# Site Development Plan\_v1.pdf Markup Summary

**OFFICE WAREHOUSE**  
**DEVELOPMENT PLAN - MINOR AMENDMENT**  
9425 PEACEFUL VALLEY ROAD  
COLORADO SPRINGS, COLORADO 80905

SITE /LANDSCAPE PLAN

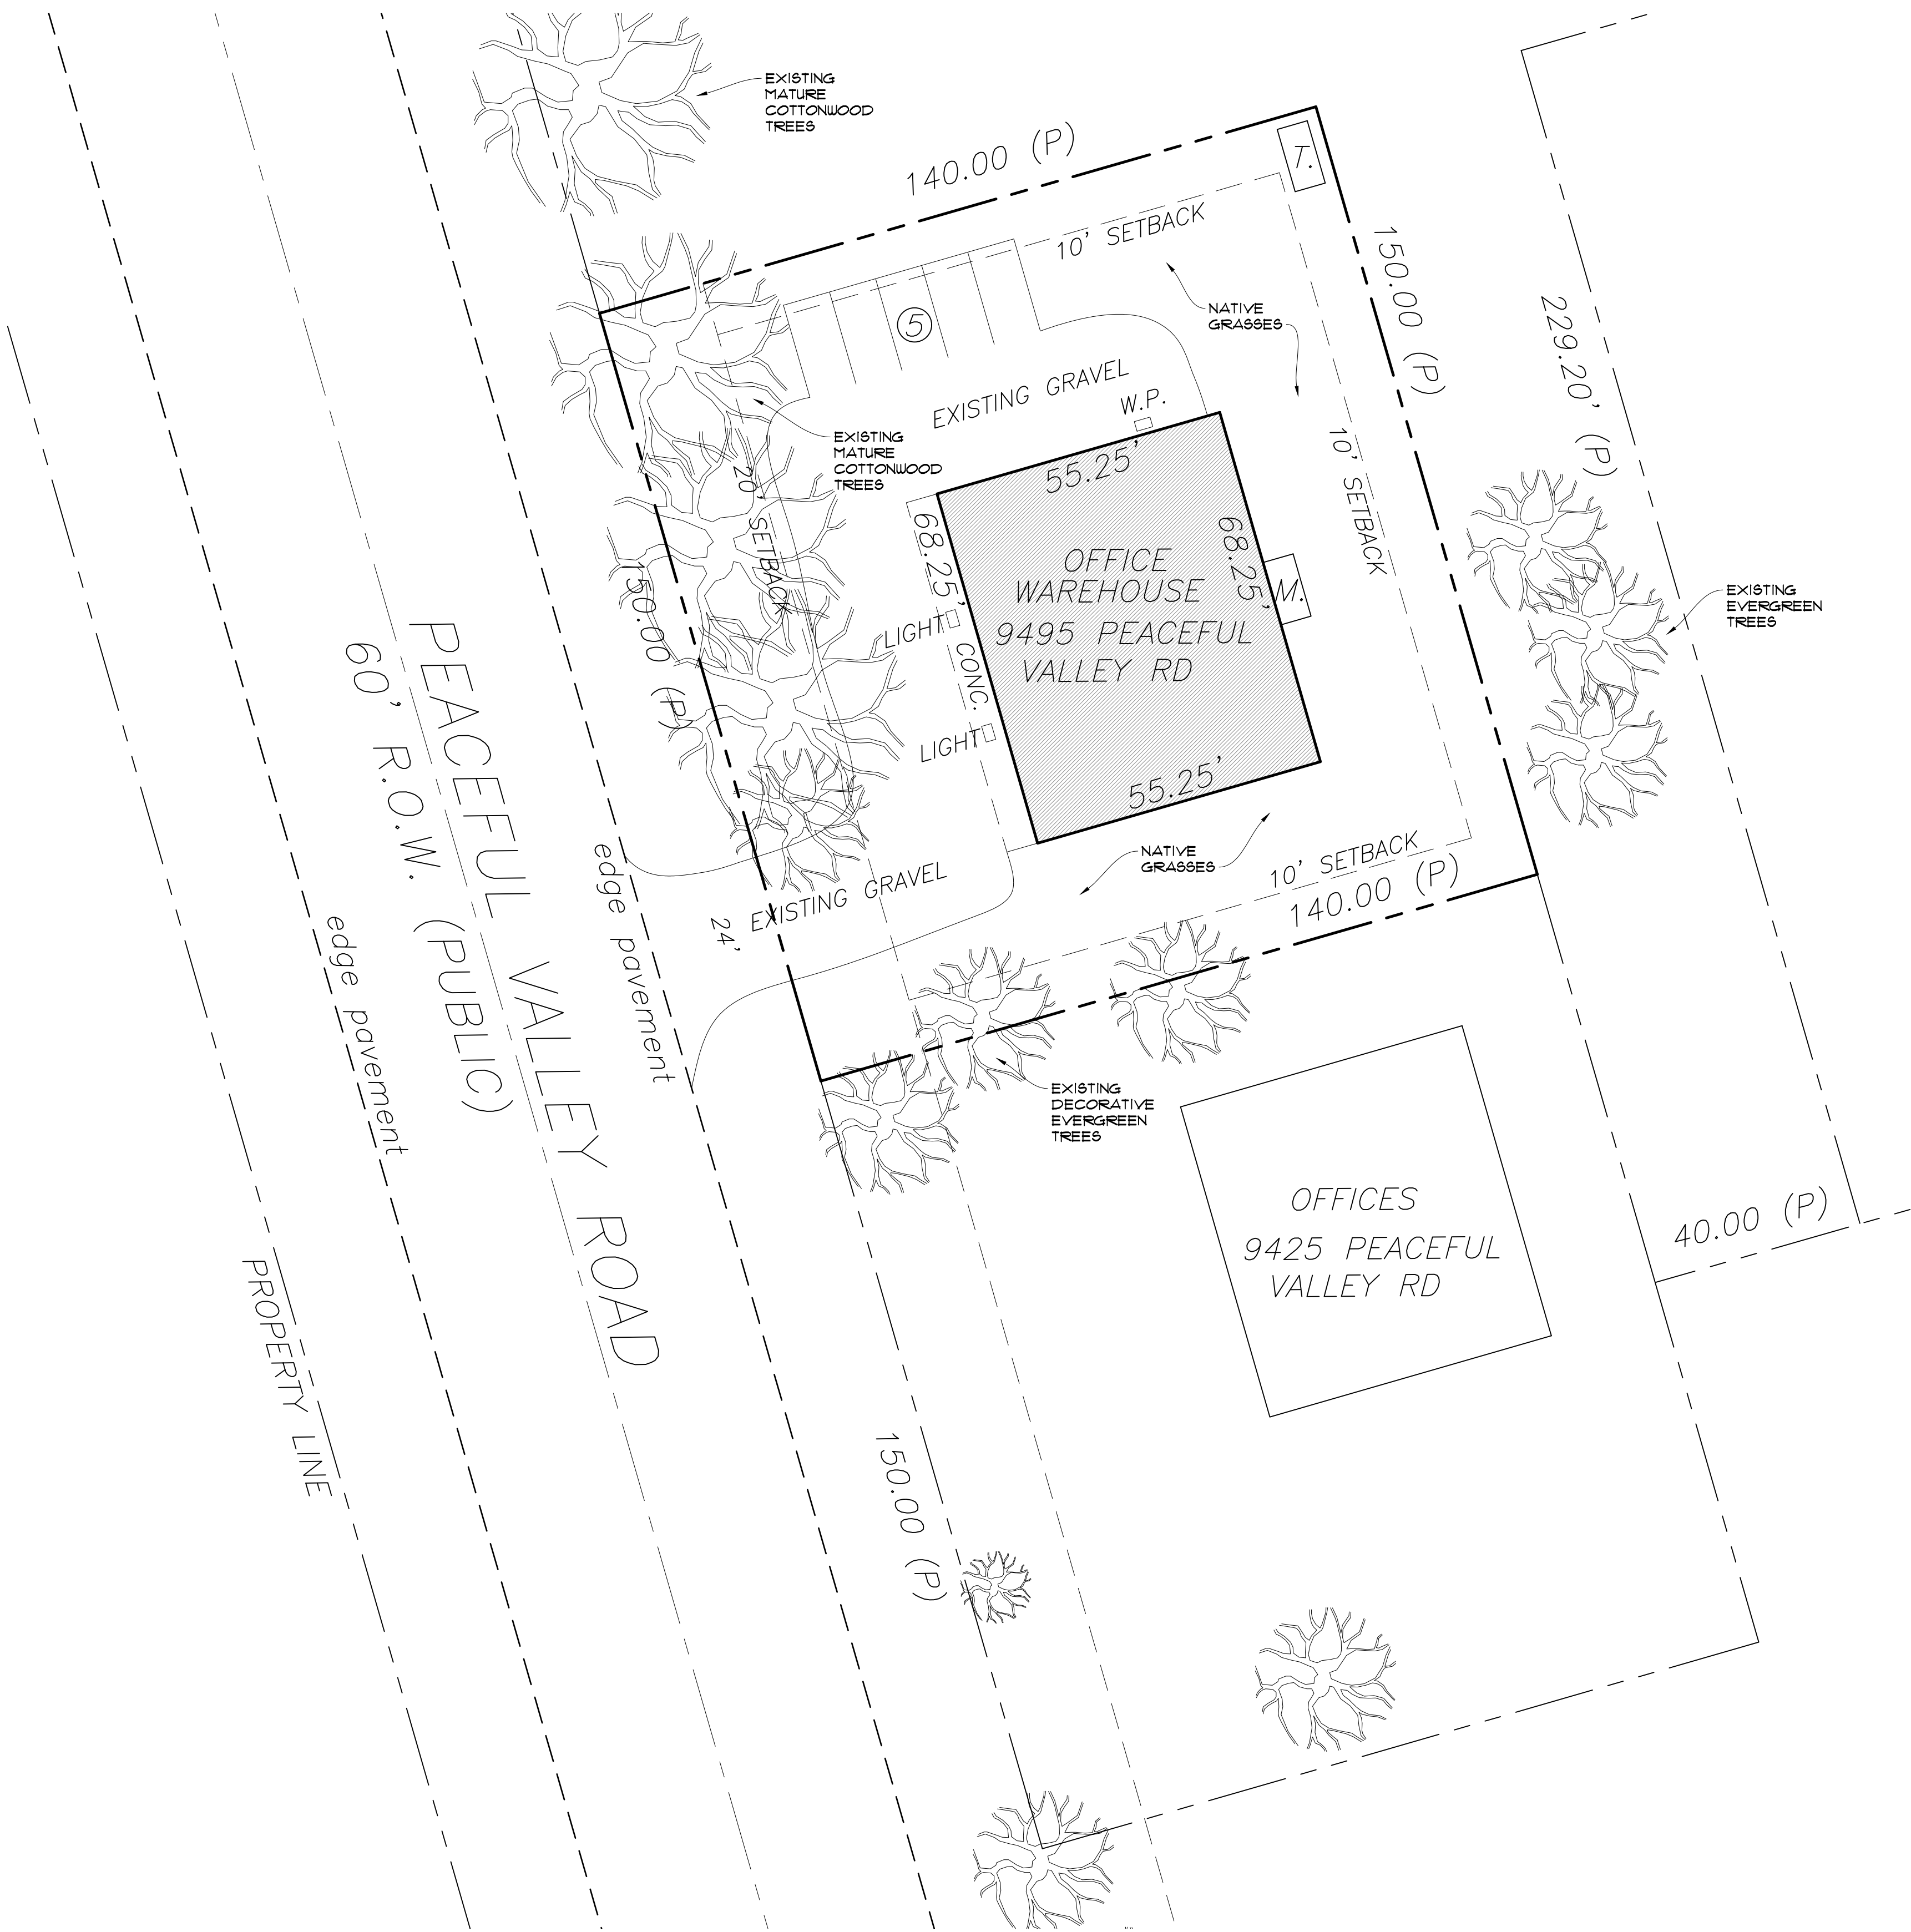
The following note should be added to all site development plans or non-residential site plans, as applicable, prior to PCD approval:  
The parties responsible for this plan have familiarized themselves with all current accessibility criteria and specifications and the proposed plan reflects all site elements required by the applicable ADA design standards and guidelines as published by the United States Department of Justice. Approval of this plan by El Paso County does not assure compliance with the ADA or any regulations or guidelines enacted or promulgated under or with respect to such laws.

Parking and ADA detail required - dimensions for spaces and drive aisles required

Add PCD File # to all pages

Distances on all four sides of structure are required  
Floor plan must be submitted in order to review uses for parking requirements
